**METHODIST LADIES COLLEGE – SSD 6484 MOD 1  
45 PARK ROAD, BURWOOD**

The modification application (SSD 6484 MOD 1) for the MLC Senior School Campus was publicly exhibited between 2 November and 15 November 2016.

In an email dated 24 November 2016, Burwood Council has questioned whether the proposed modification can be considered substantially the same development, and has raised some concerns regarding the proposed variation to the height and floor space standards contained in *Burwood Local Environmental Plan 2012* (BLEP 2012). This letter sets out the proponent's response to these matters. At the Department's request, this response focuses on Council's comments relating to substantially the same development. This response should be read in conjunction with the attached legal advice prepared by Addisons.

1 Summer Solstice @ 9am
 1:500

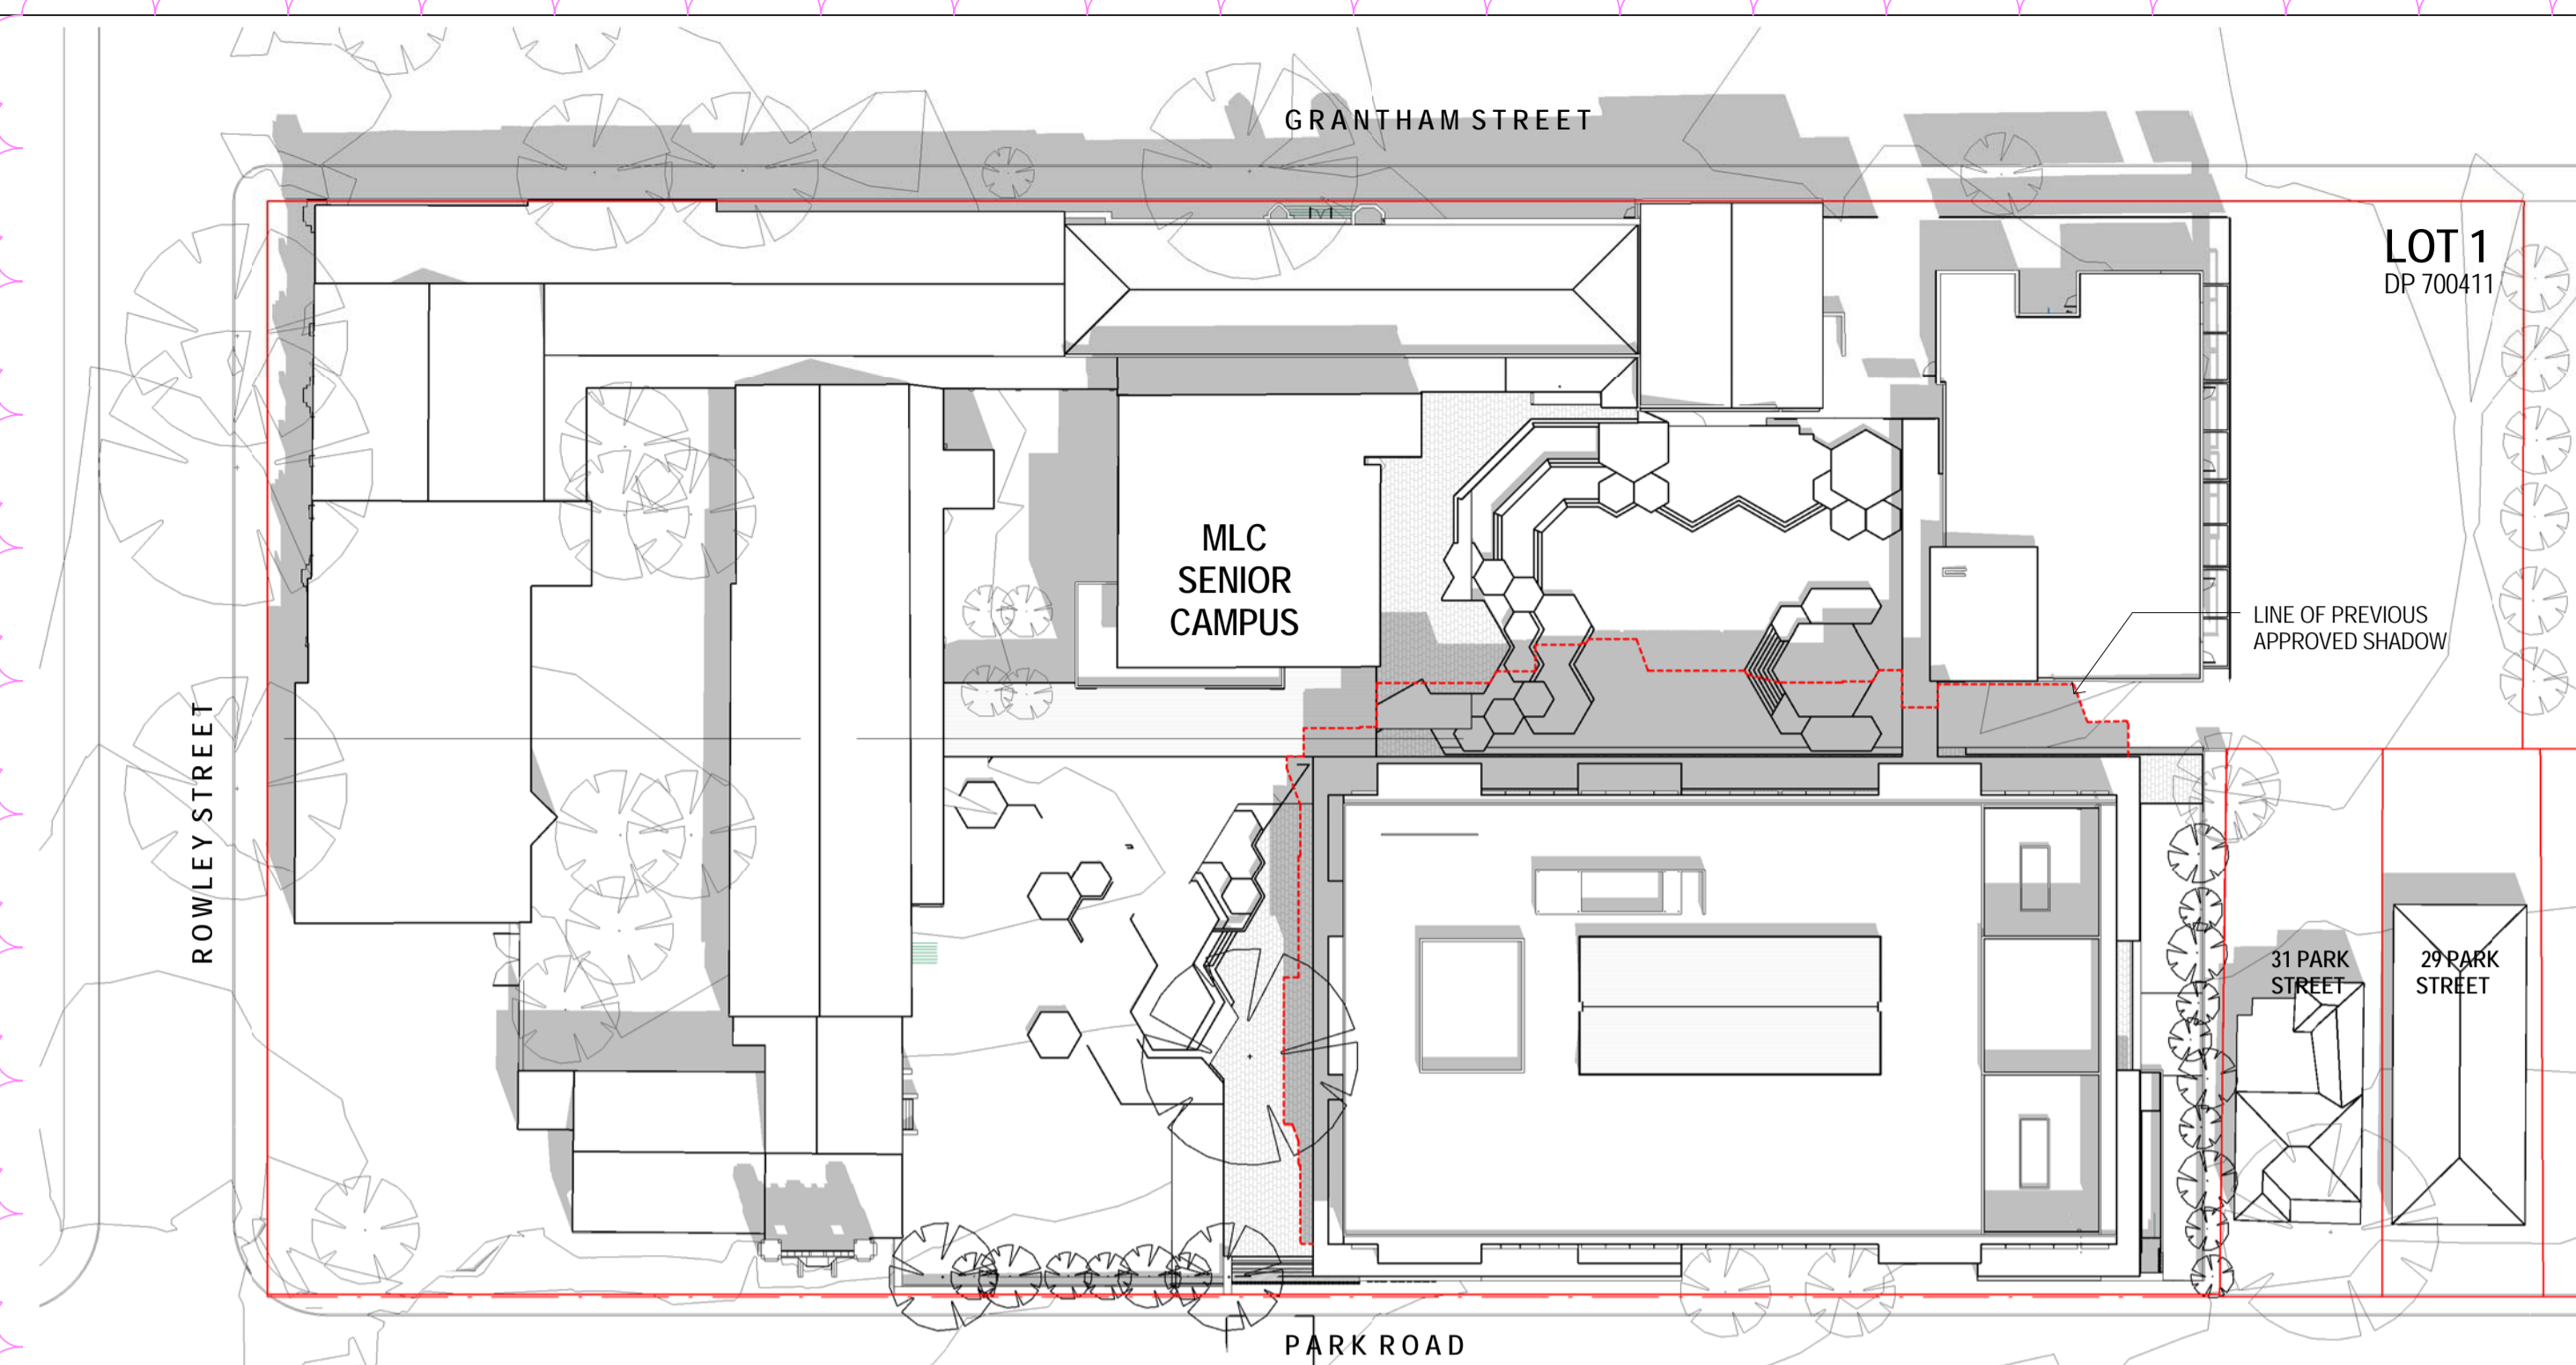
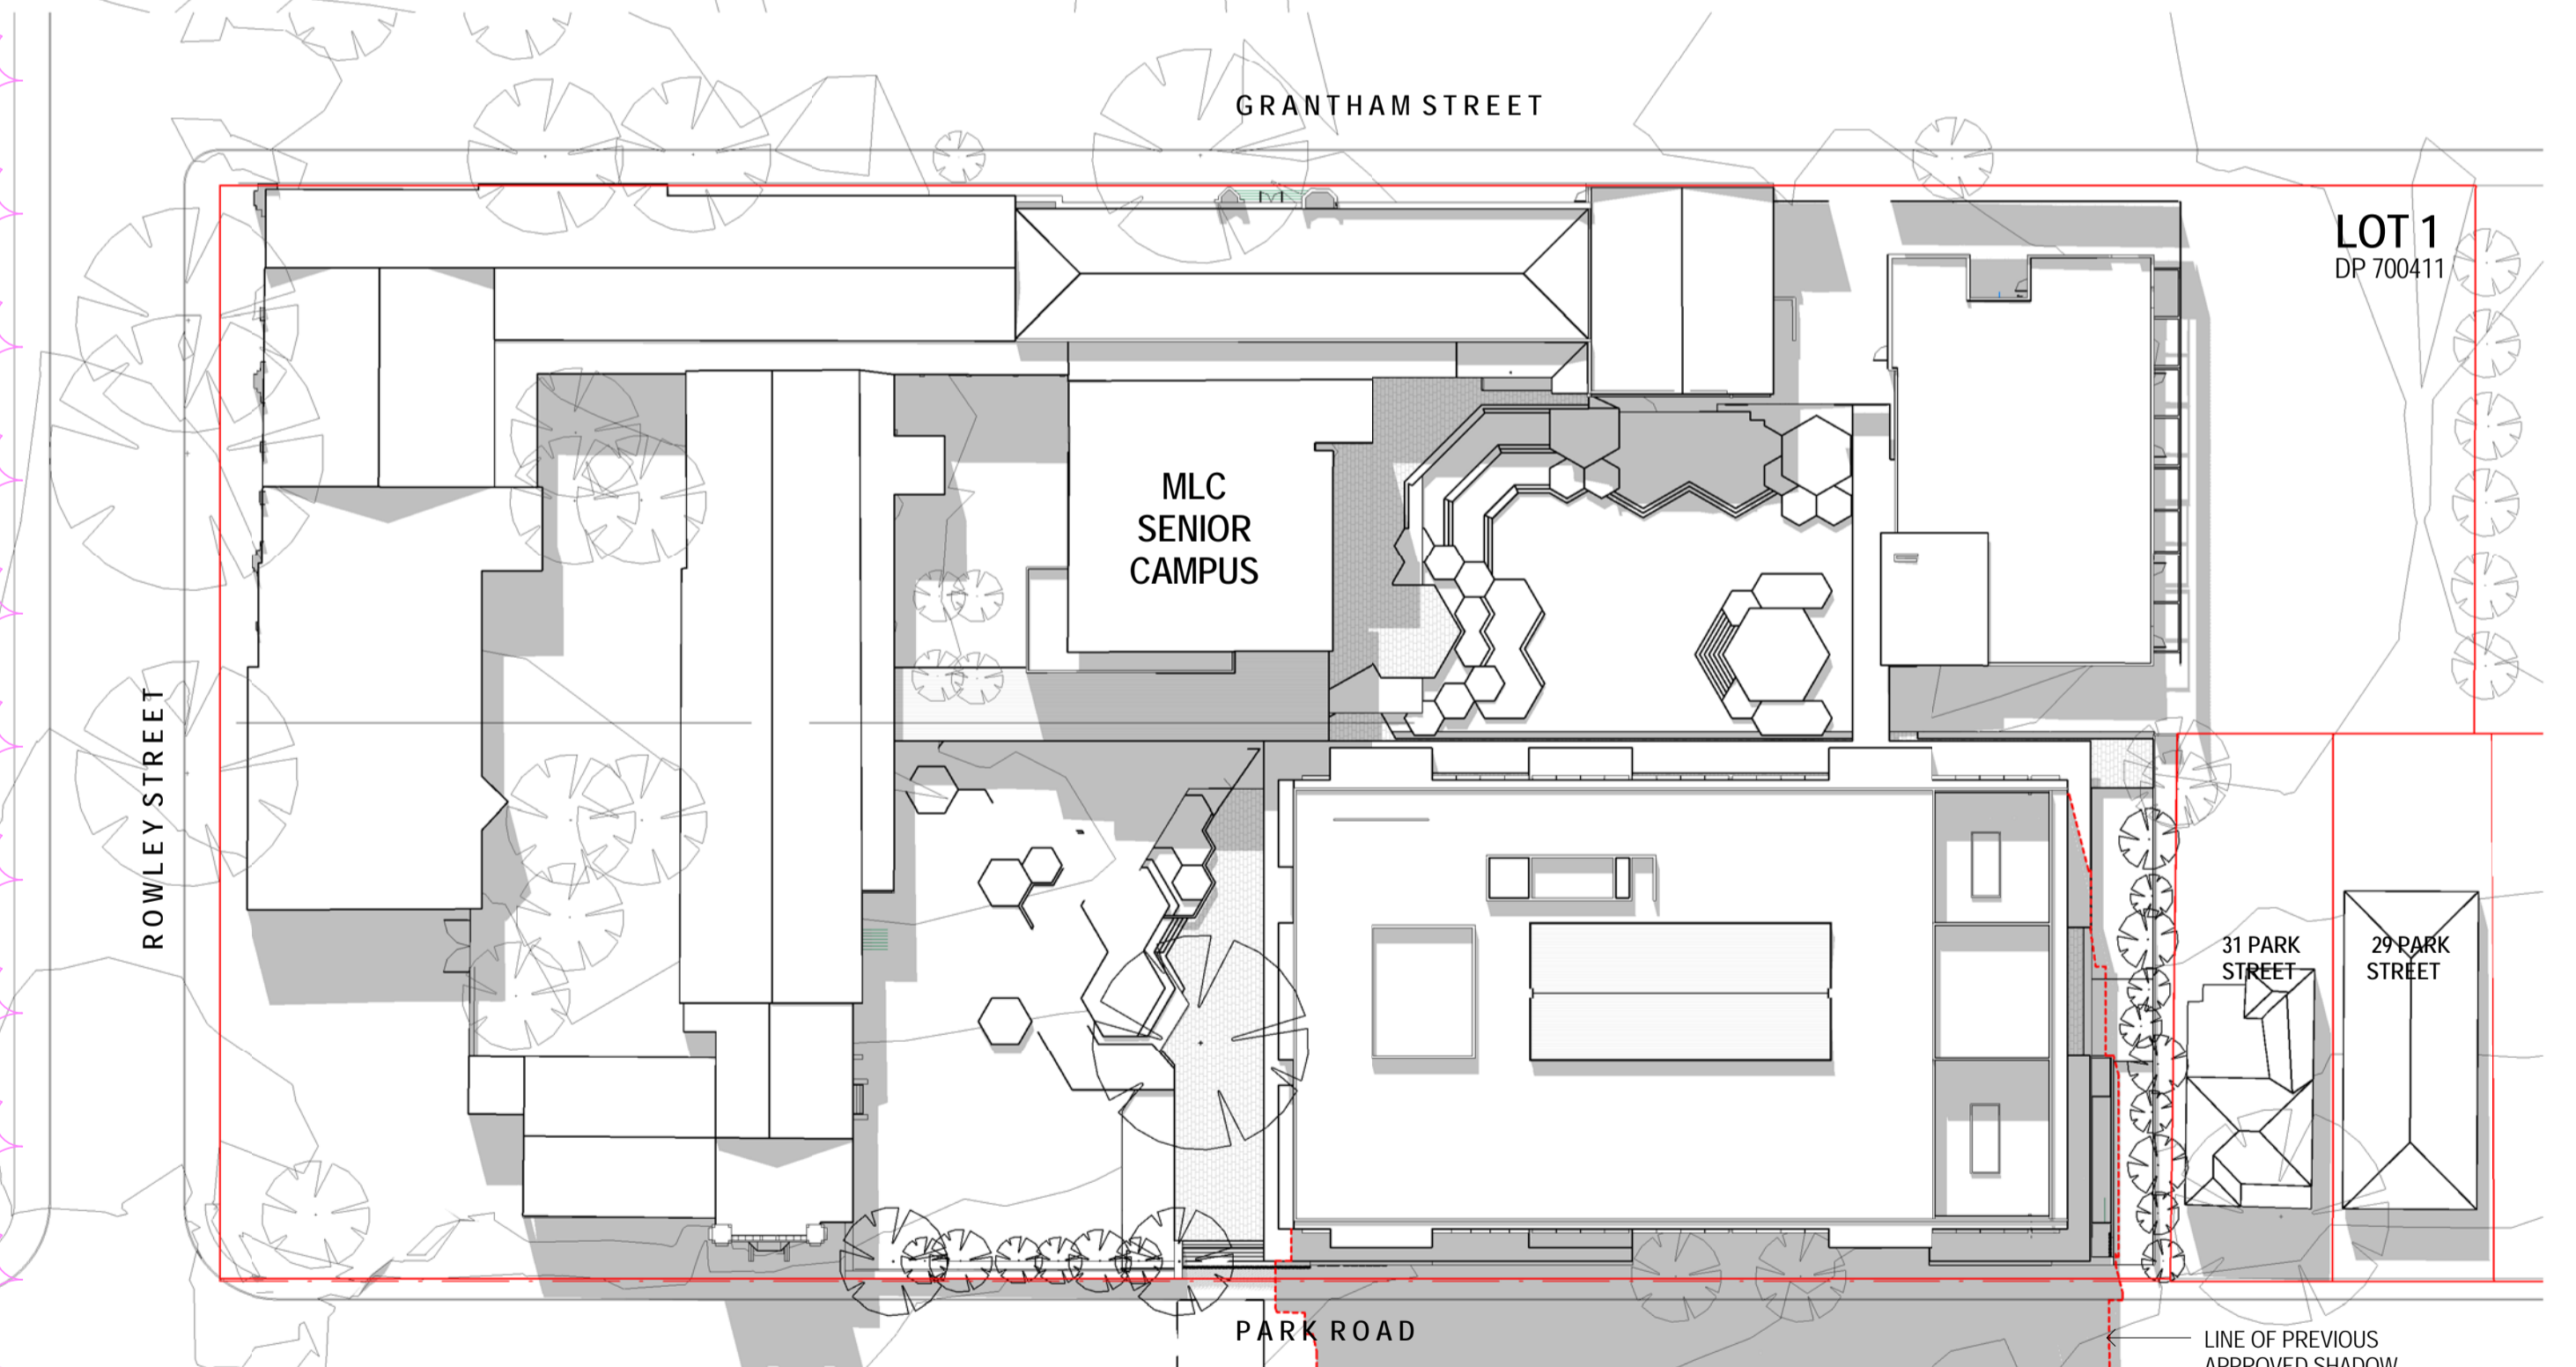
**The impacts from the proposed scale of the development are considered to result in substantial changes to shadow impacts. The proposed outdoor learning area on the upper storey also has the potential to reduce aural privacy of surrounding developments.**

The proposed change to the building envelope of the Teaching and Learning Building results in shadow impacts that are minor in nature. As shown in the Revised Architectural Plans at Attachment A of the modification application, the additional shadow impacts to the south occur only in the late afternoon from 3pm onwards on the summer and winter solstice, with all additional shadow impacting the school's tennis courts. Due to the limited duration of the overshadowing and the absence of any impacts on private property, the impacts can reasonably be considered to be minor in nature.
